Located At 254 COMMERCIAL ST
Merrill's Wharf - Pierce Atwood Law Offices

Job ID: 2011-05-1135-FAFS

Conditions of Approval:

Installation of a Master box fire alarm system

FIRE ALARM
 RISER DIAGRAMS
E3.2
 09.23.2010

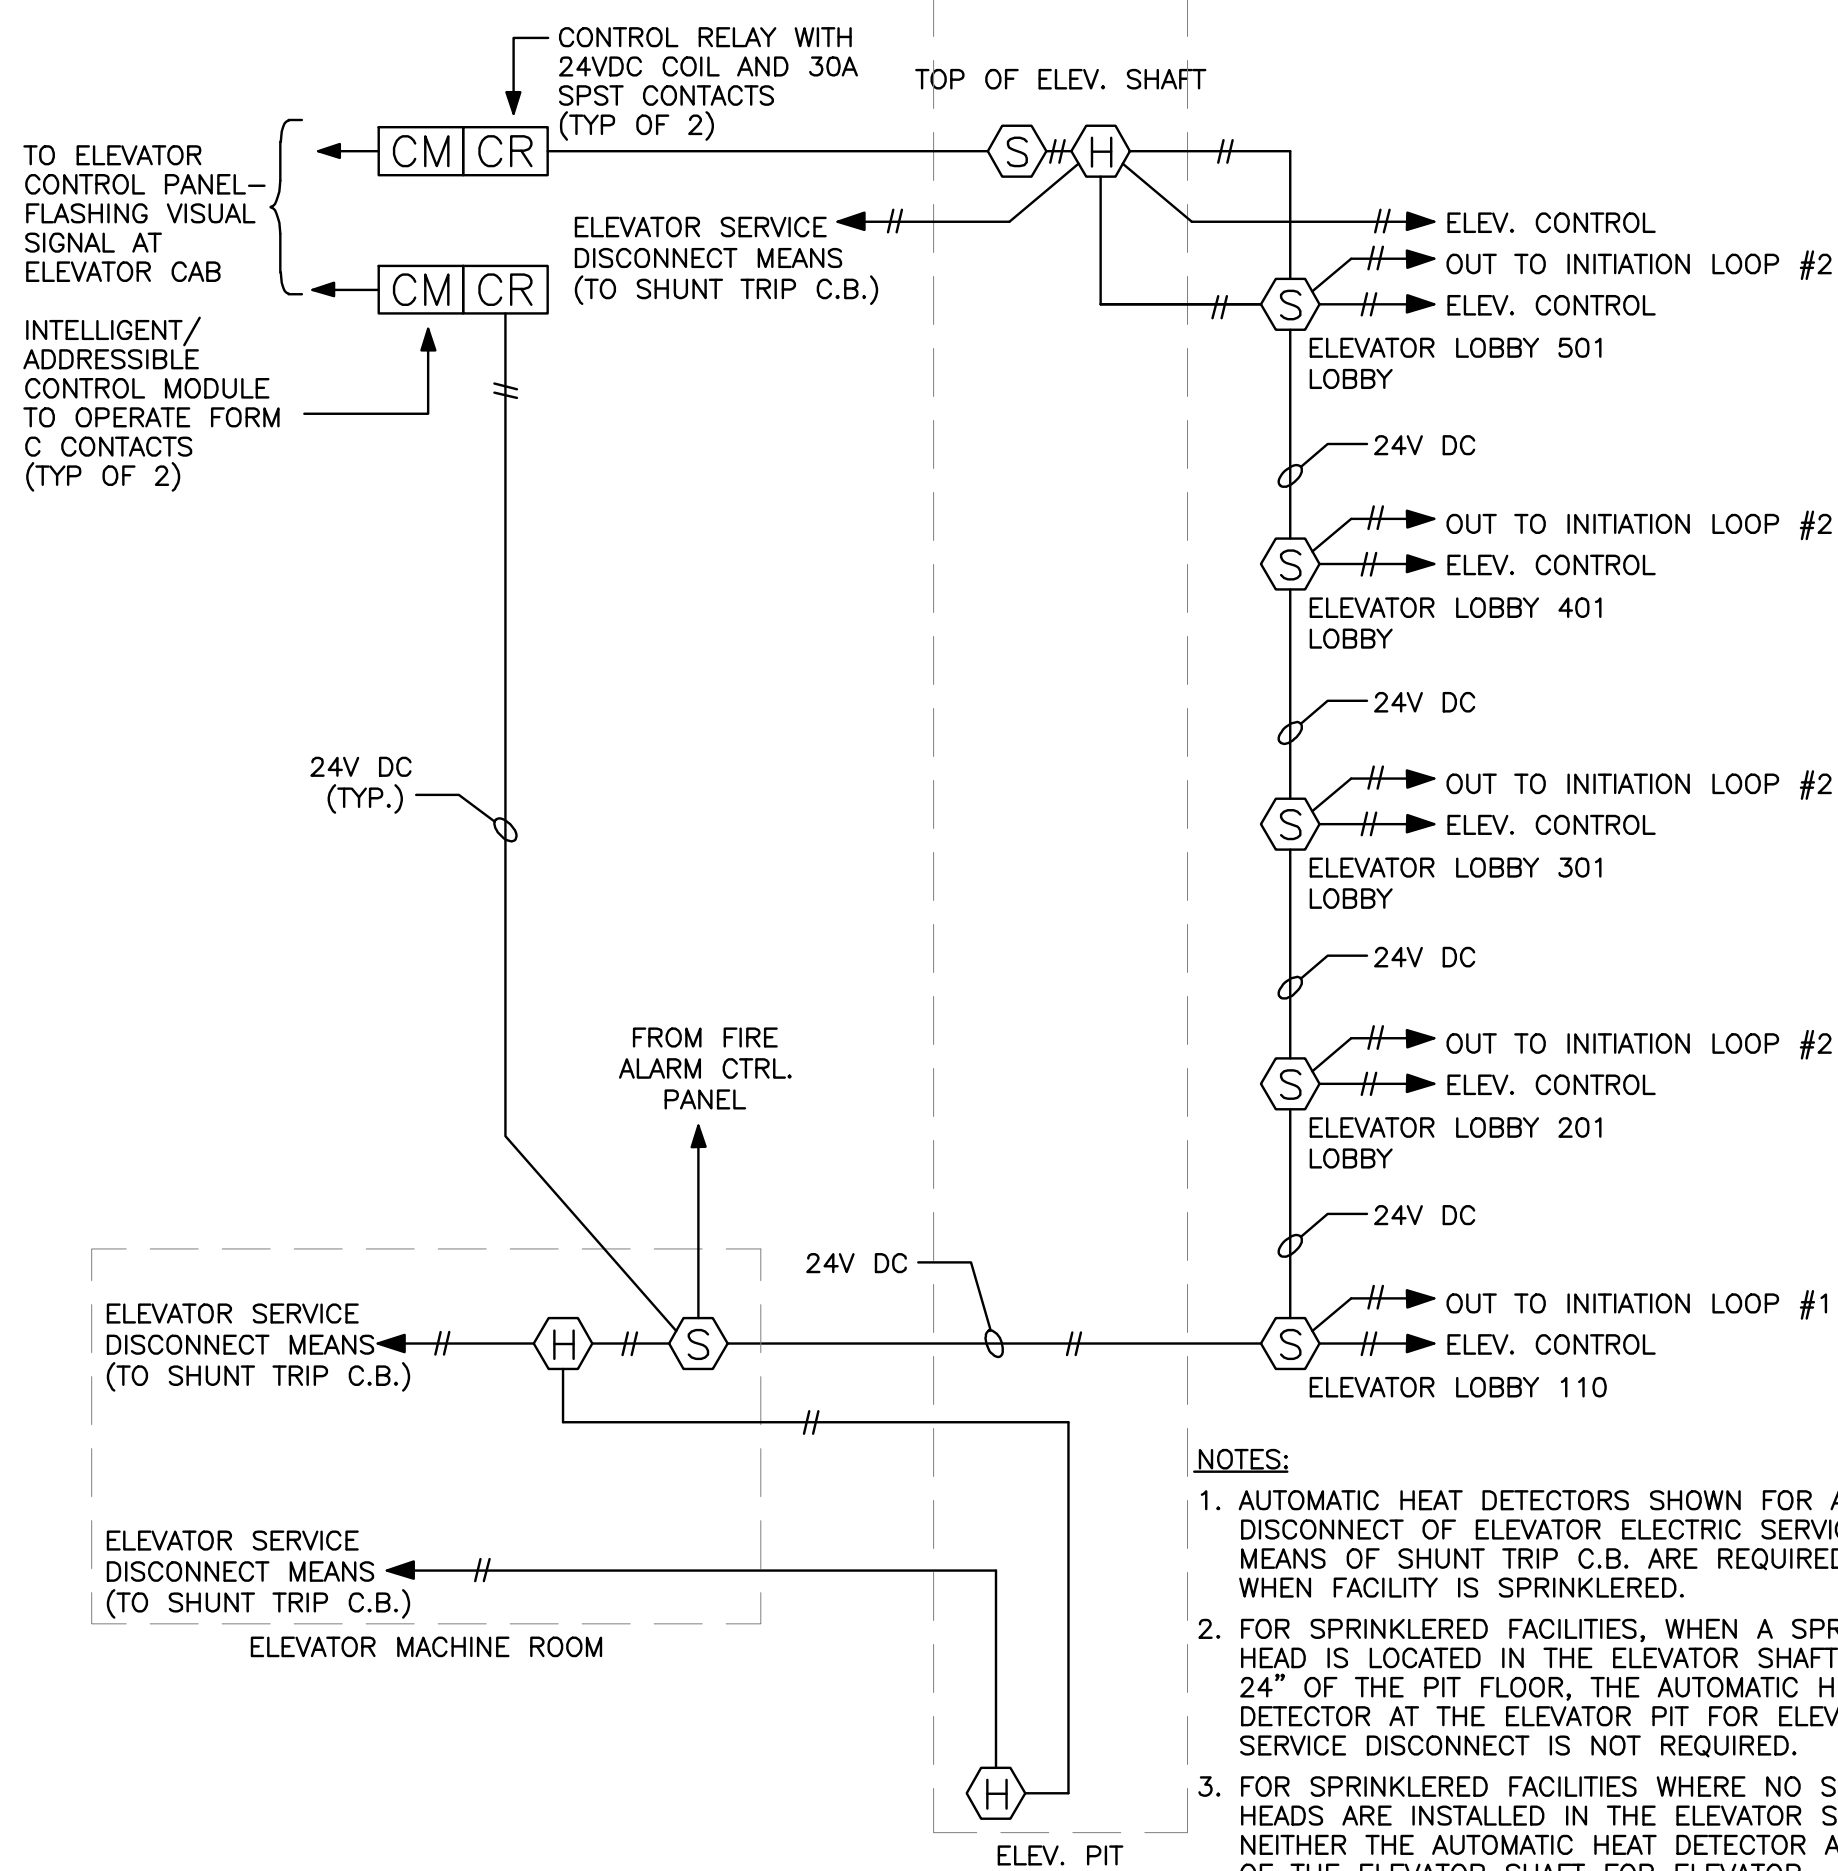
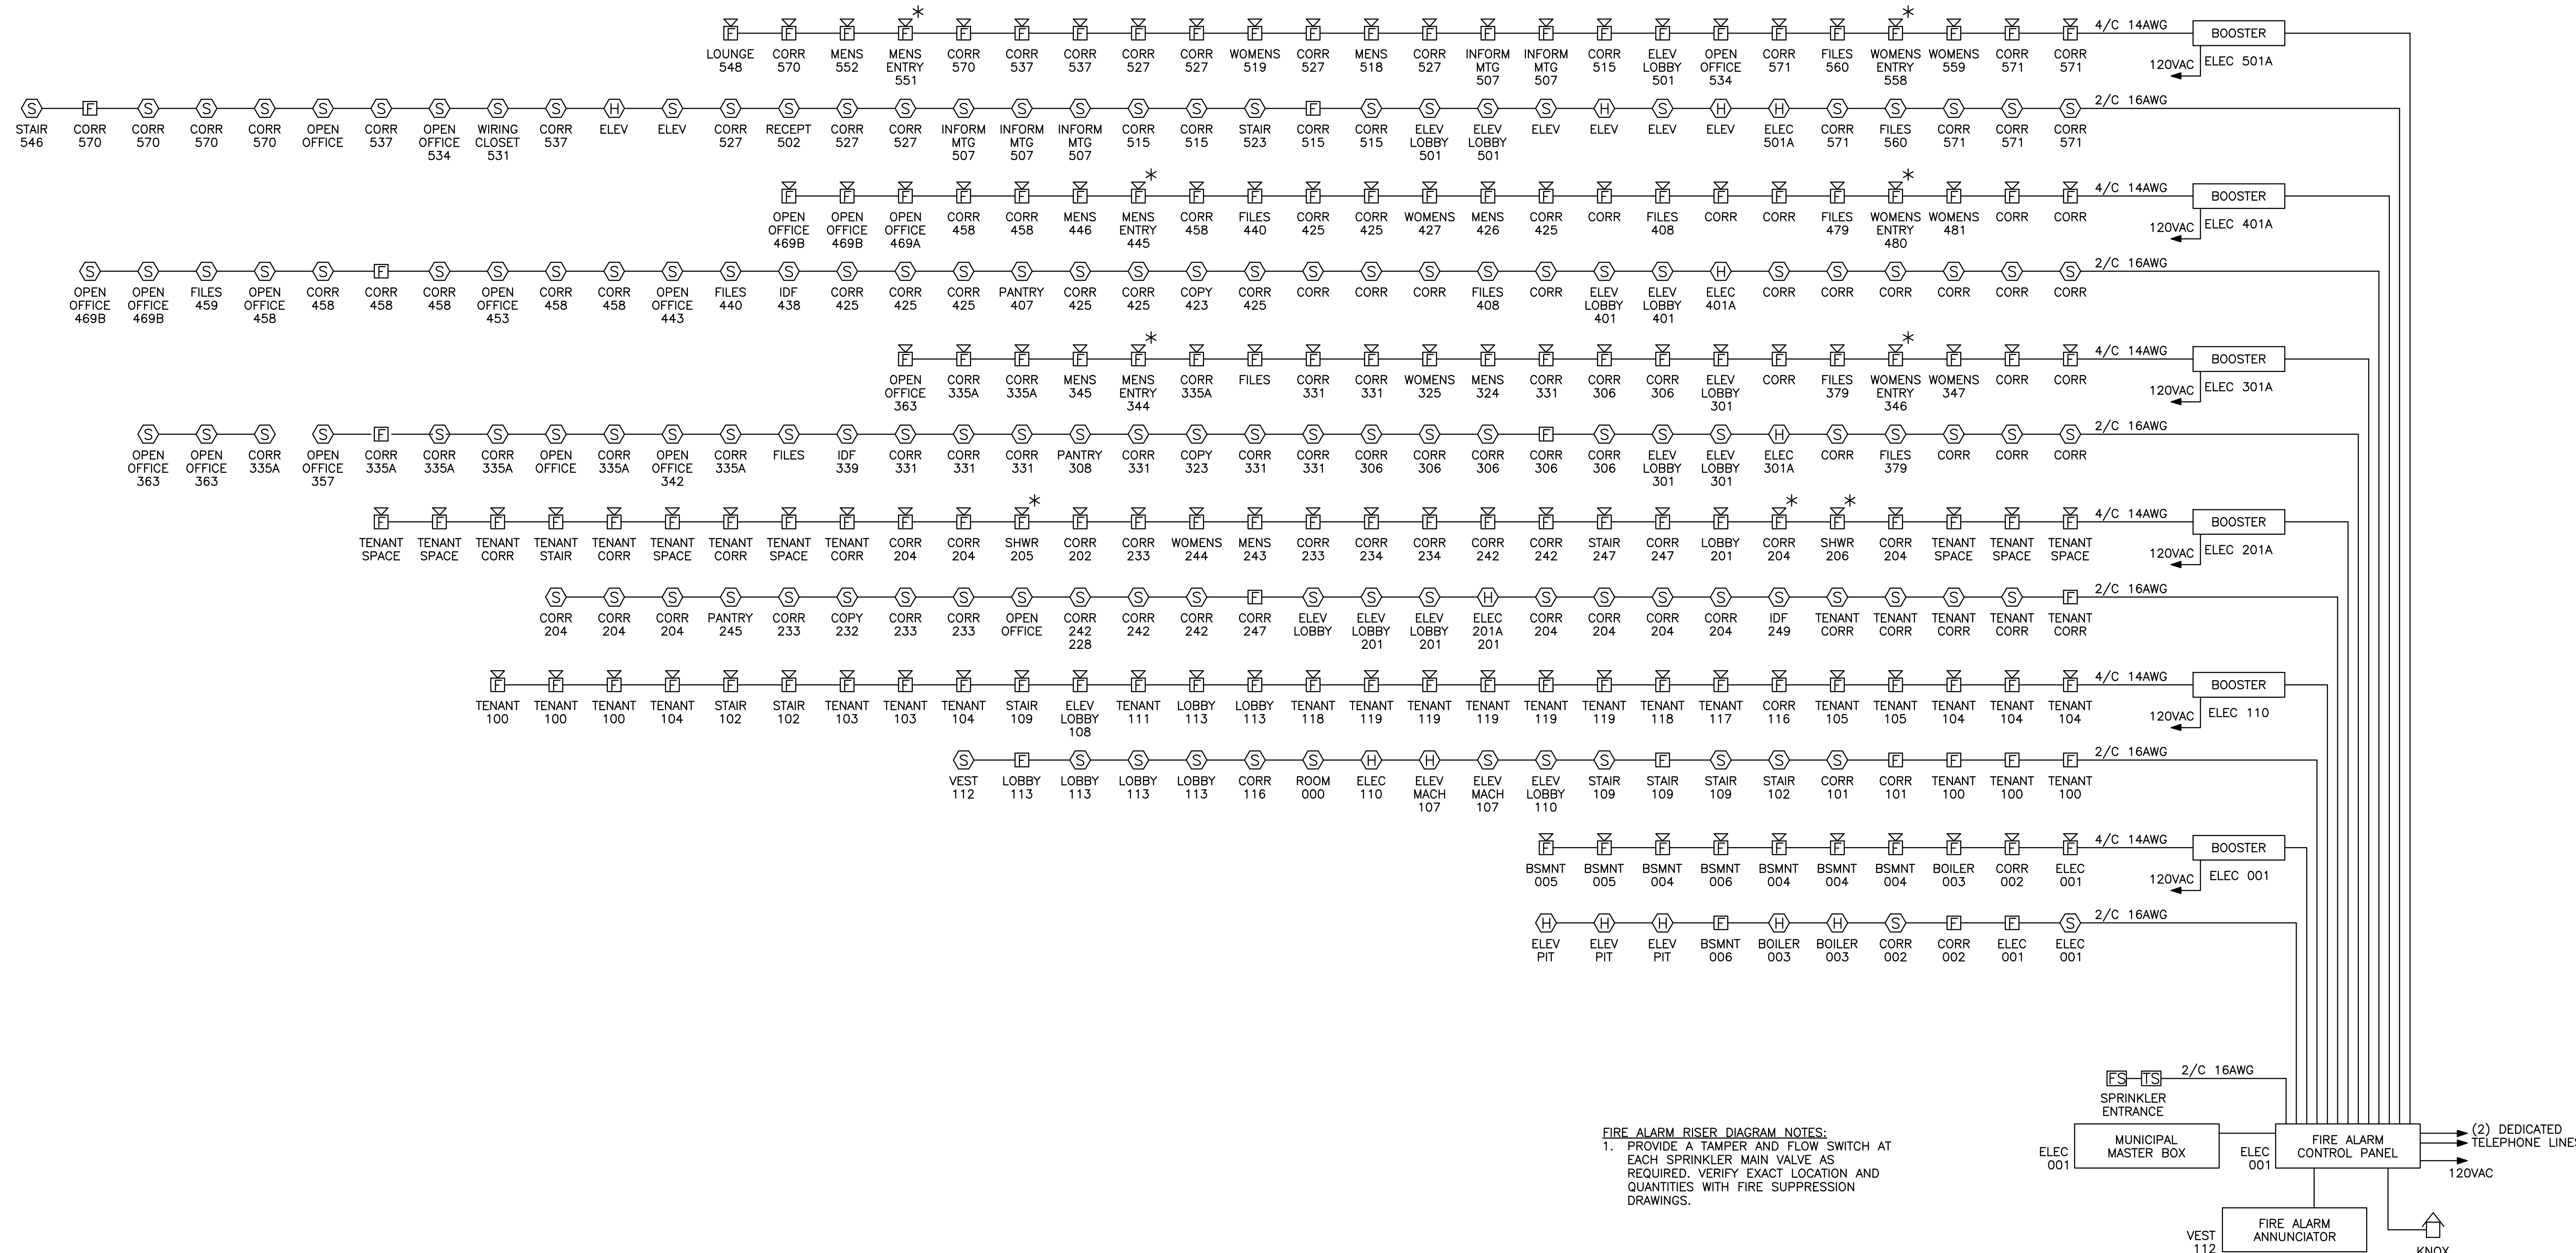
Duct detection shall be supervisory and not trip the evacuation signals or master box.

Sprinkler water flow and supervision by floor is required.

AES Zones shall be: 1- Water flow; 2- City Disconnect; 3- pull stations and detectors; 8 AES tamper.

Zones 1 and 3 shall have individual City Disconnect. The FACP and annunciators shall indicate "City Disconnect: Water Flow" or "City Disconnect: Pulls and detectors".
